# **East Anglia ONE North and East Anglia TWO Offshore Windfarms**

## **Applicants' Comments on Substation Action Save East Suffolk's Deadline 12 Submissions**

Document Reference: ExA.AS-10.D13.V1

Date: 5<sup>th</sup> July 2021

Rev	Date	By	Comment	Approved:	FM				Figure	2

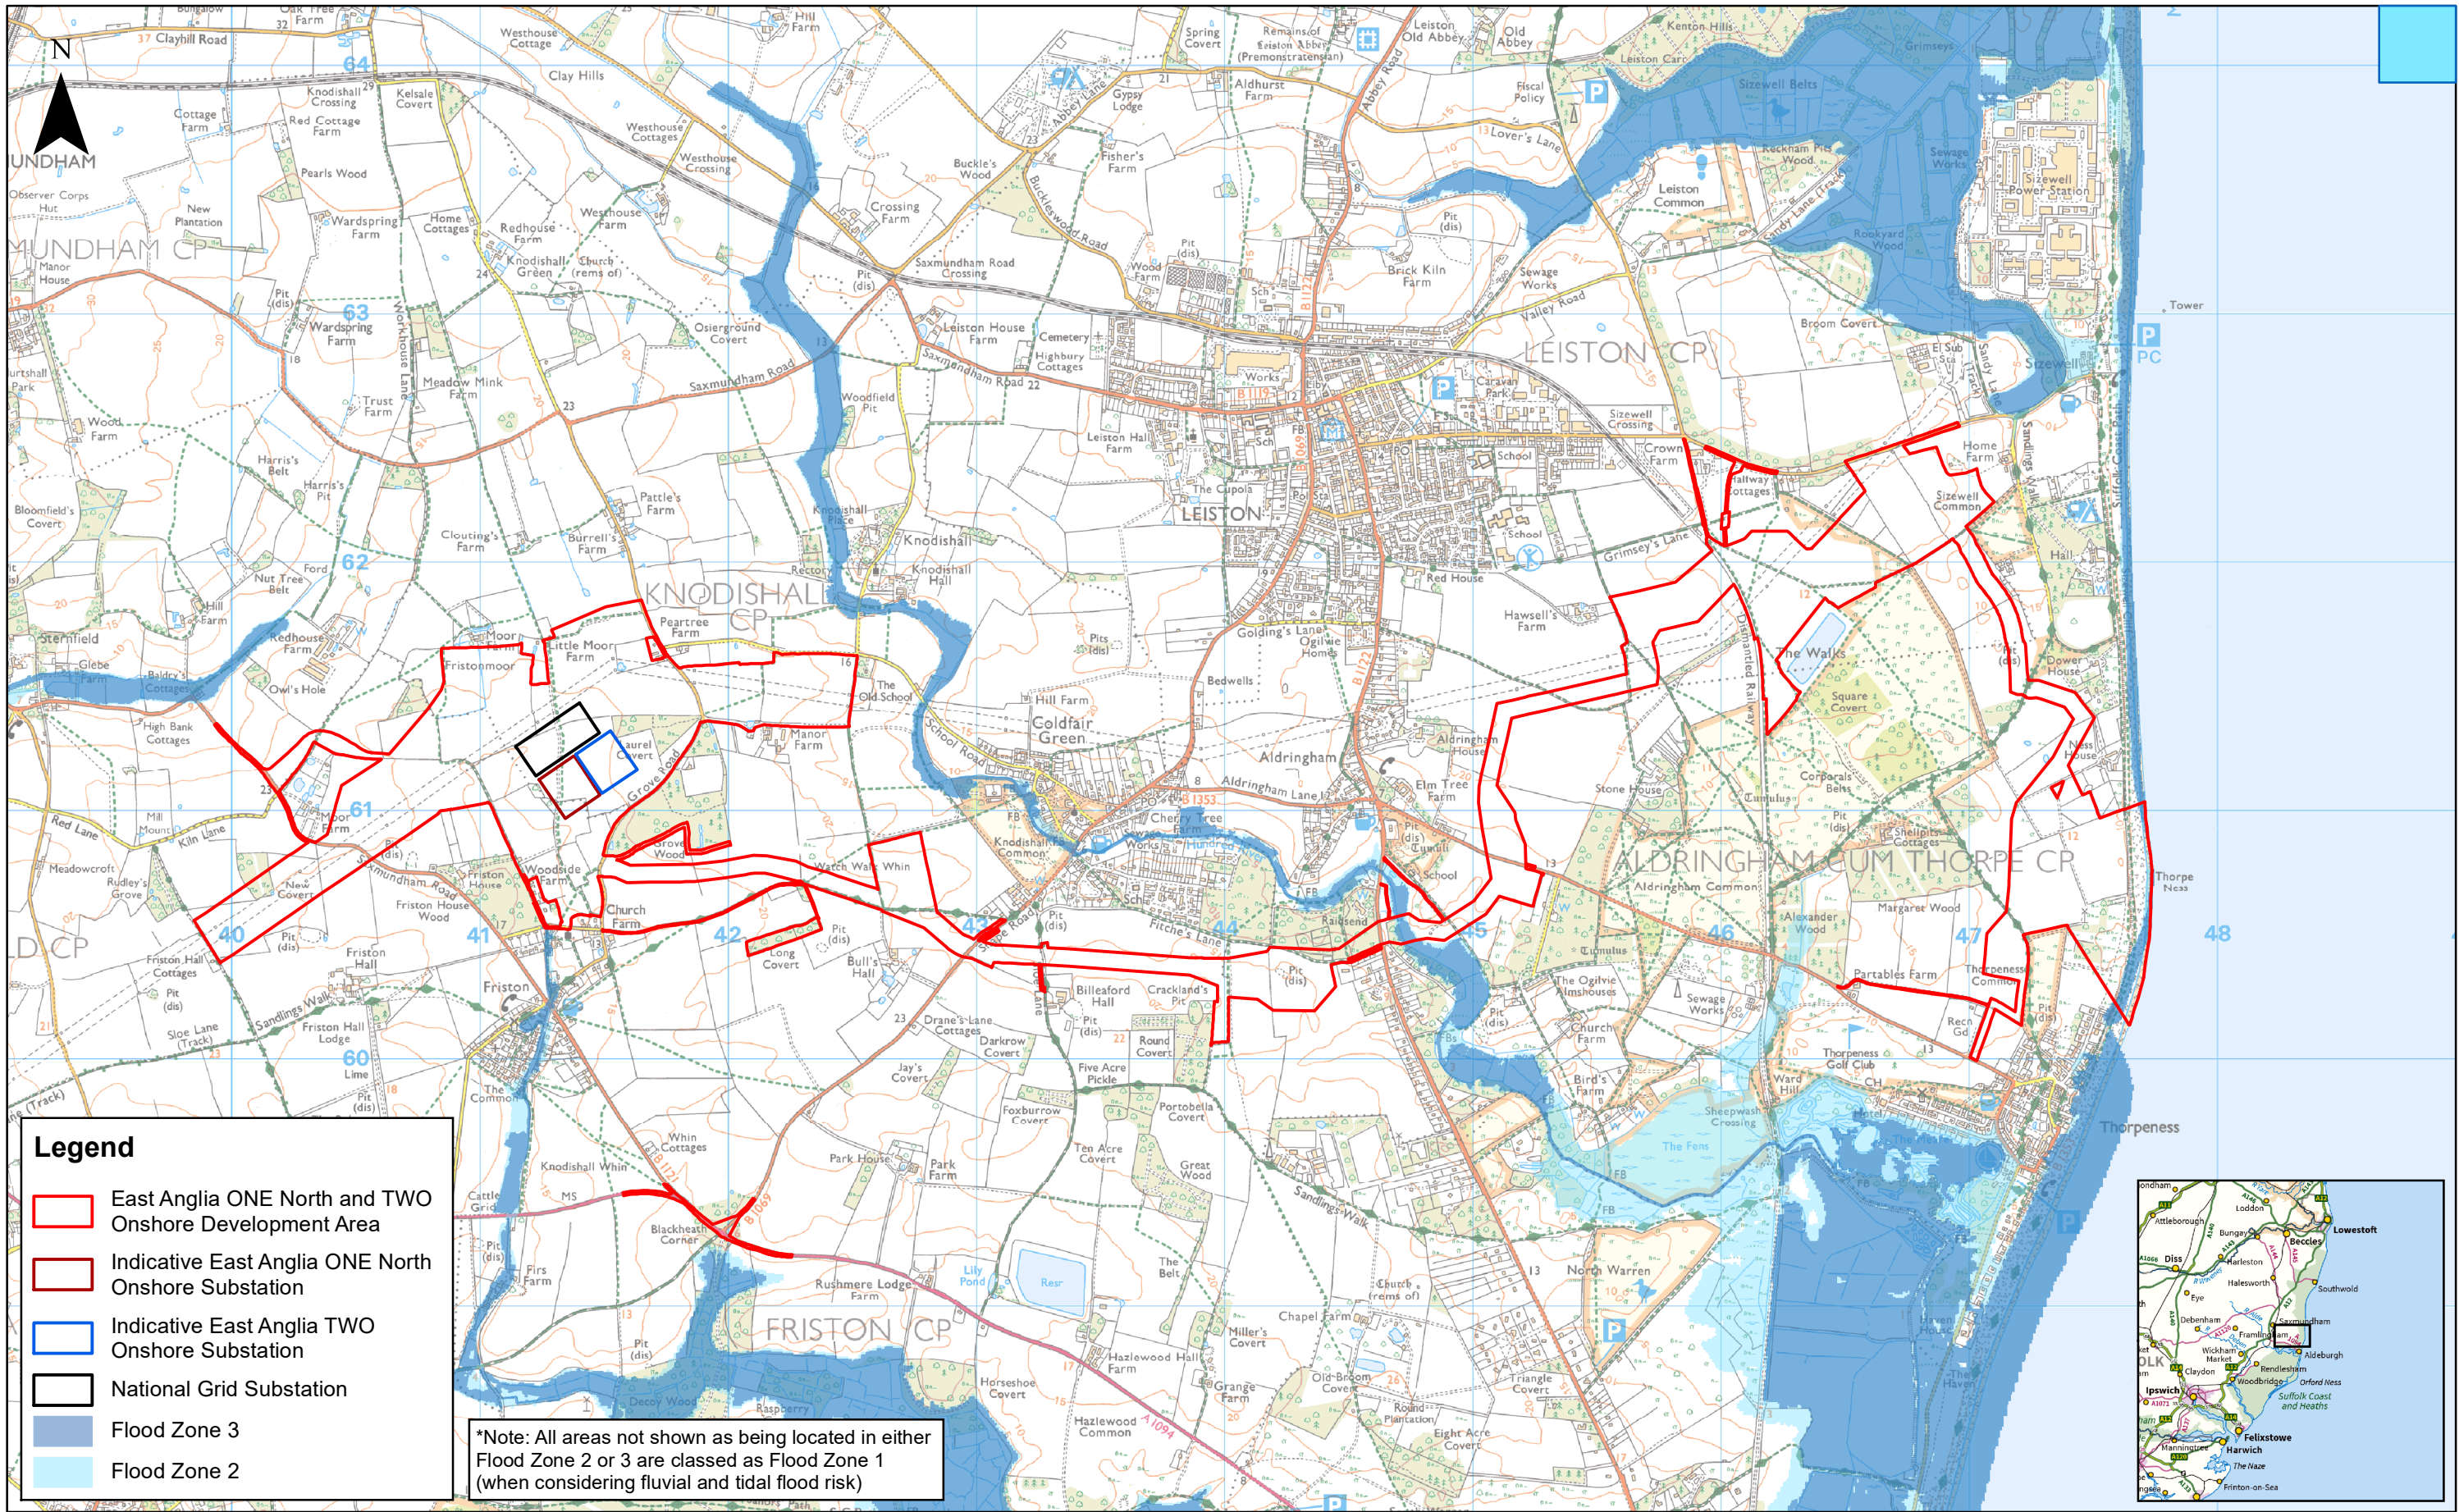
ID	SASES's Comment	Applicants' Comments
	<p>with peak flows or lower treated flows and blockage risks. We note in Figure 2 there is a construction area west of the National Grid sub-station a substantial part of which is at lower elevation than the pond it is meant to drain into. We also observe that the orientation of the southern basin is different from that shown in the OODMP – see comments below.</p> <p>In conclusion, the Applicant has not demonstrated the viability of delivering a construction phase surface water management scheme to prevent increased flood risk to Friston.</p>	<p>existing drainage network (Friston Watercourse), into which the attenuated and treated surface water will be discharged.</p> <p>The Applicants clarify that the location of the construction drainage basins is not fixed at this outline stage, and that the final surface water and drainage management plan will take full account of the topography within the National Grid and onshore substation locations, and the final detailed design and construction sequence.</p>
